**ADC Planning Consultation
Response from the Conservation Officer**

Application Number	Y/57/13/L & Y/56/13/
Address	Berricourt, Main Road, Yapton, BN18 0ED
Description	Application for Listed Building Consent for replacement of existing defective floor joists at second floor level, Pitched and Flat Roof to existing Listed Building with new access gate from Main Road.
Case Officer	Mr. Simon Davis

Proposed Gated Plan Entrance @ 1:100

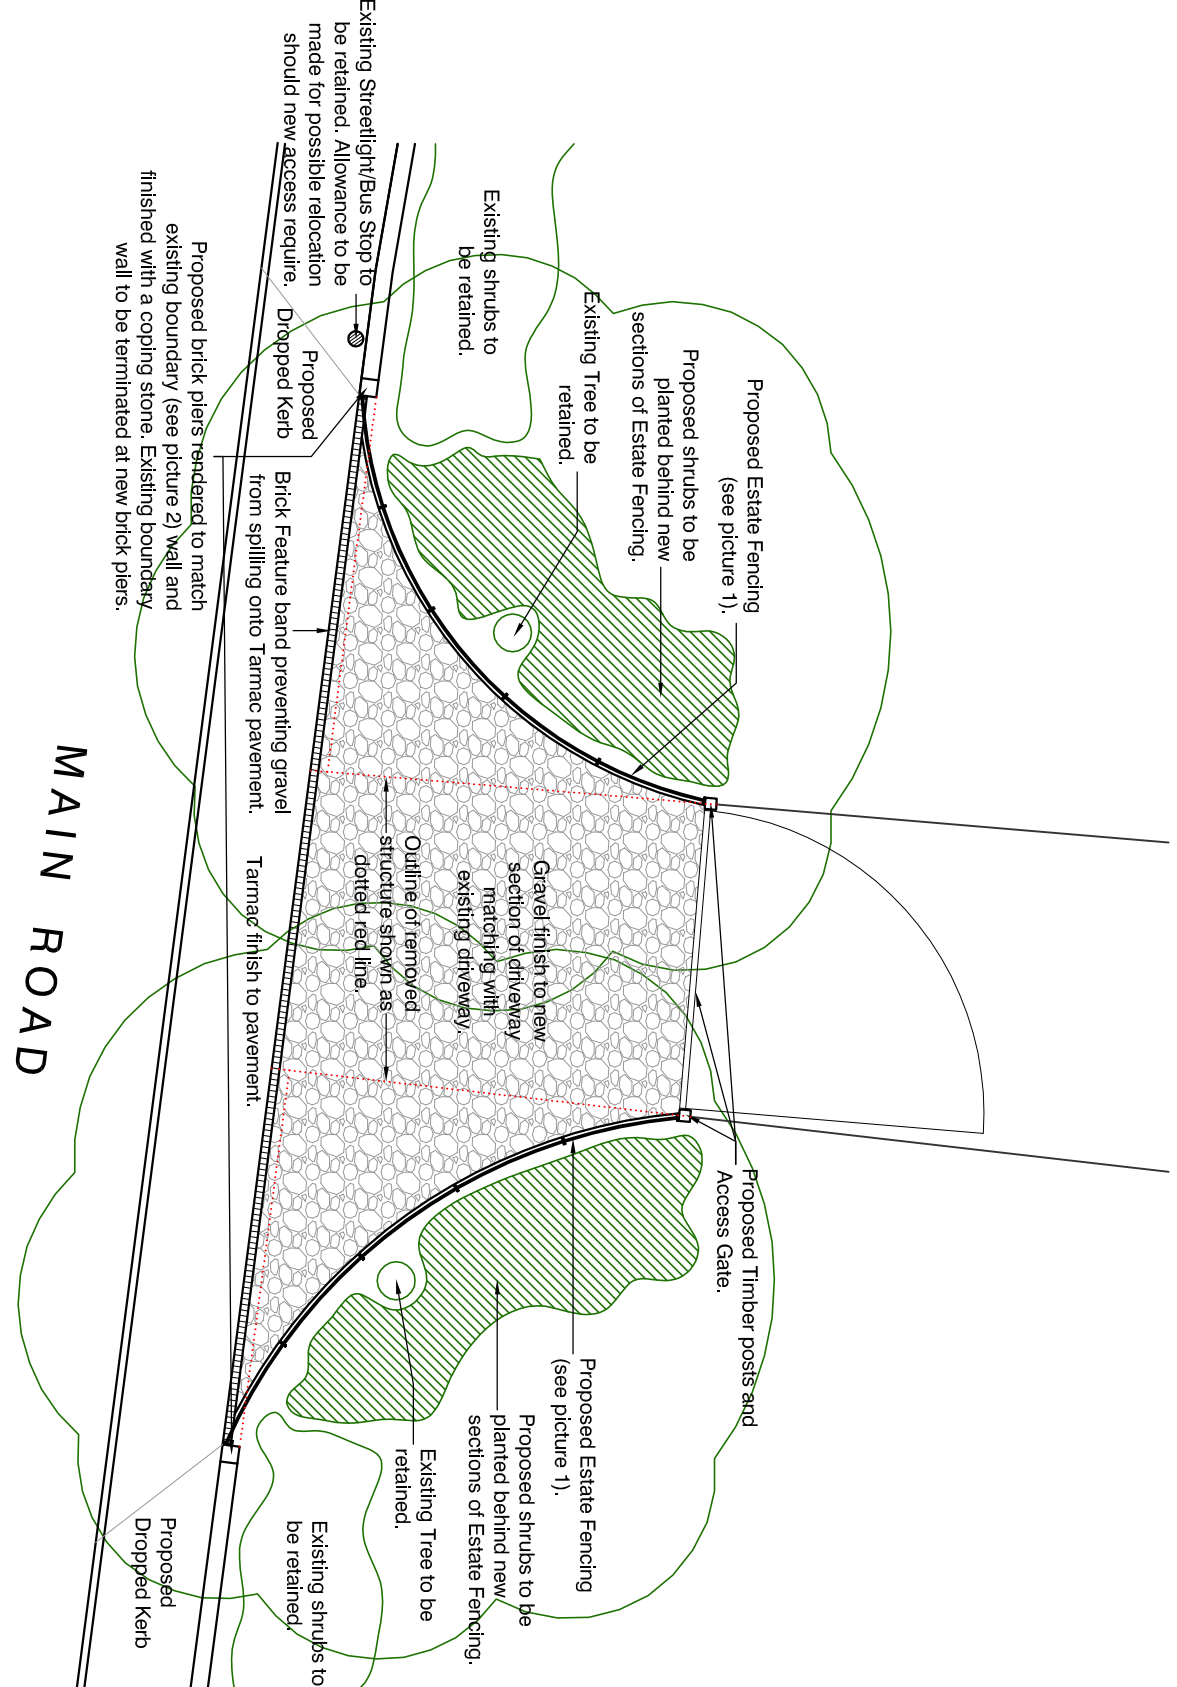
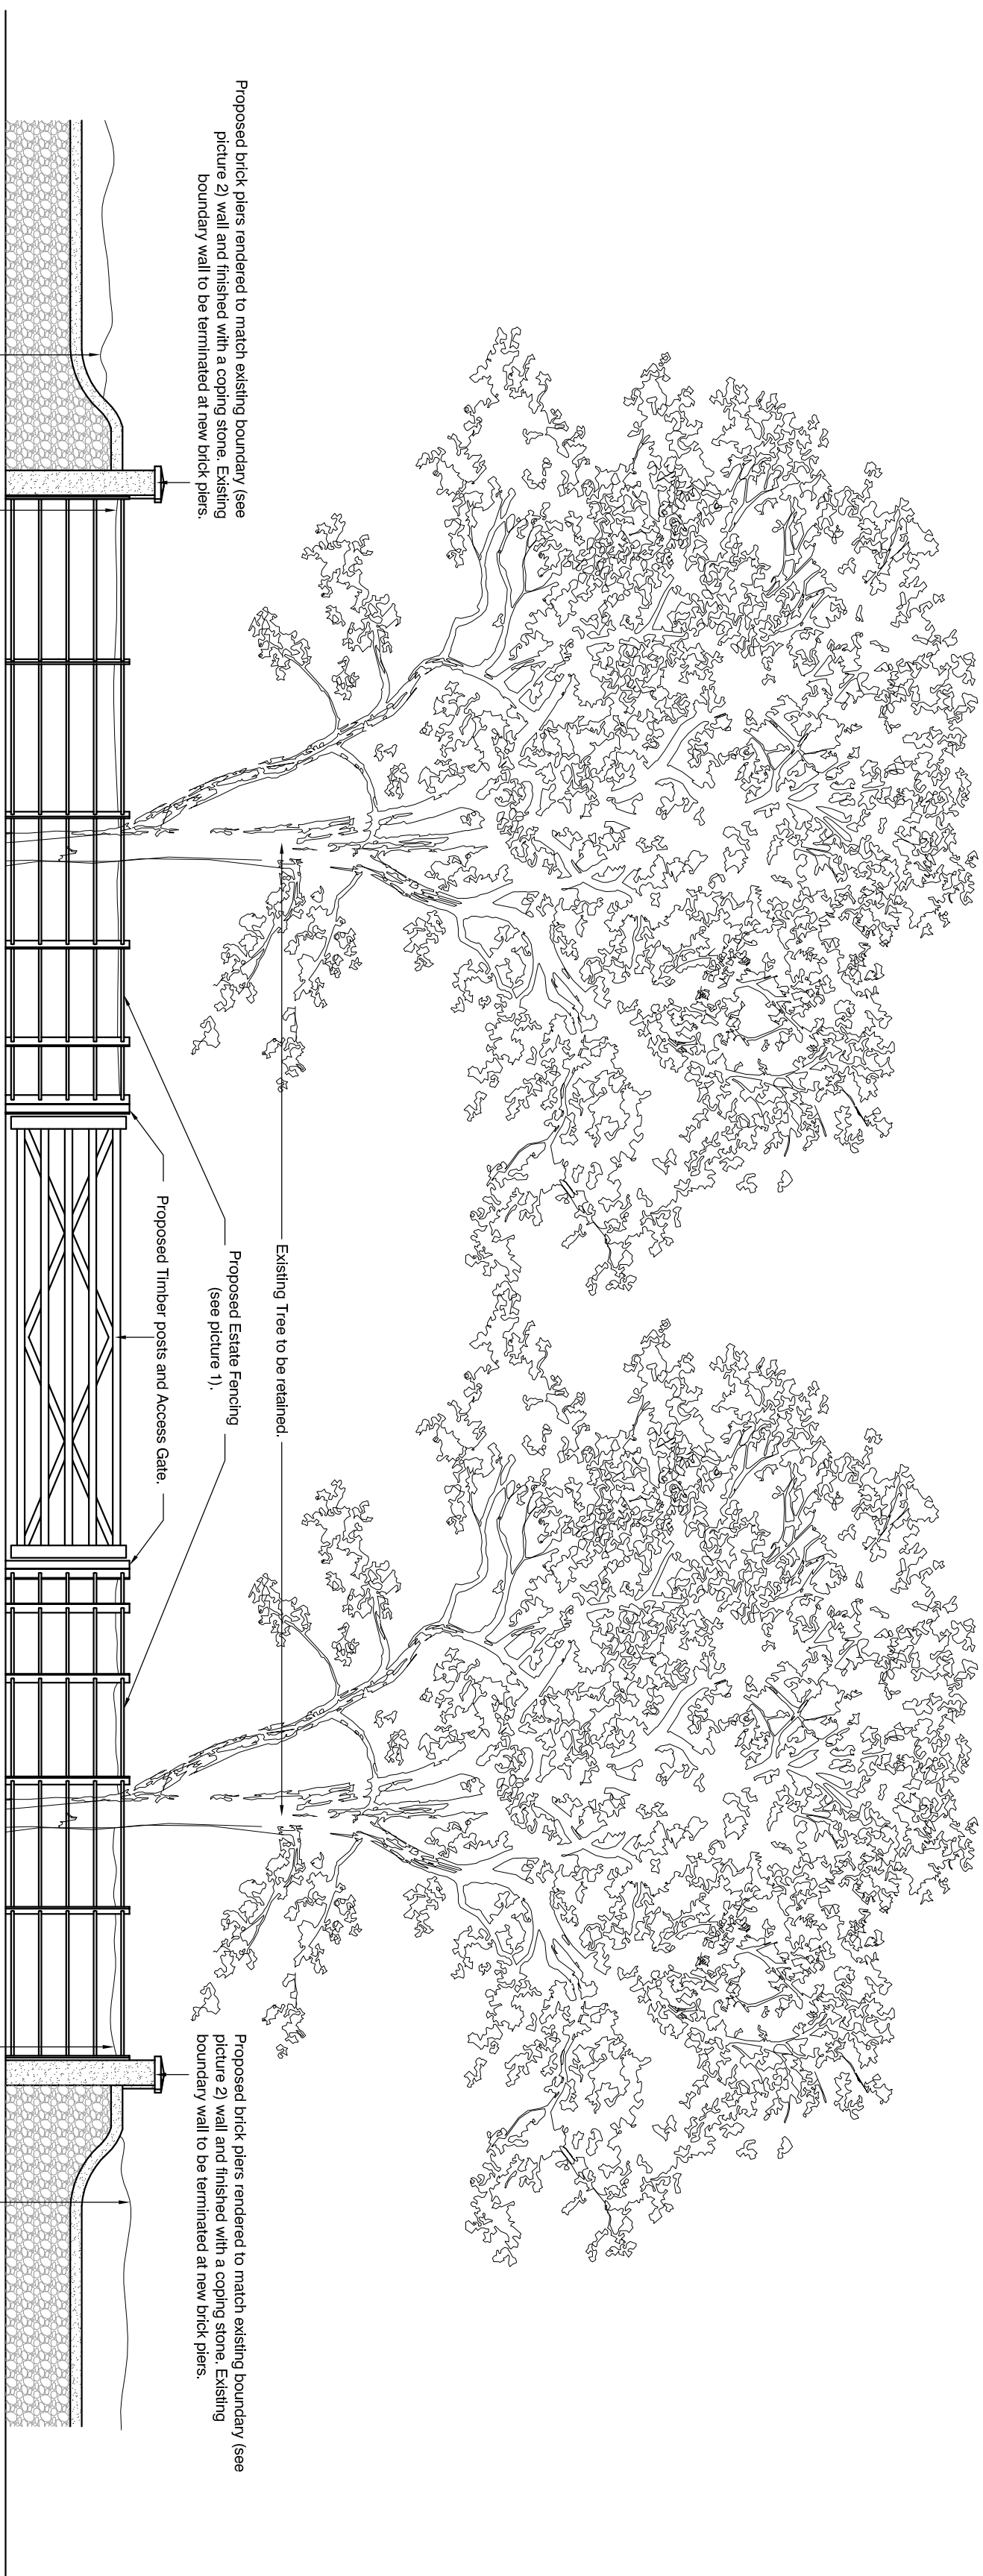
Berri court has a substantial, and very attractive, flint wall boundary treatment which is prominent as part of the local street scene. The proposal for the entrance is to enable a recessed gateway access to the property, and entails the removal of a large section of historic flint walling and its replacement with estate fencing.

The loss of the historic walling is problematic as it would result in the loss of excess historic fabric and alter the character of this part of the street; the provision of an overtly large opening in an area dominated by attractive walling with few openings.

A more suitable alternative which retains the existing walling should be sought. This could involve the use of the estate fencing behind the existing flint wall.
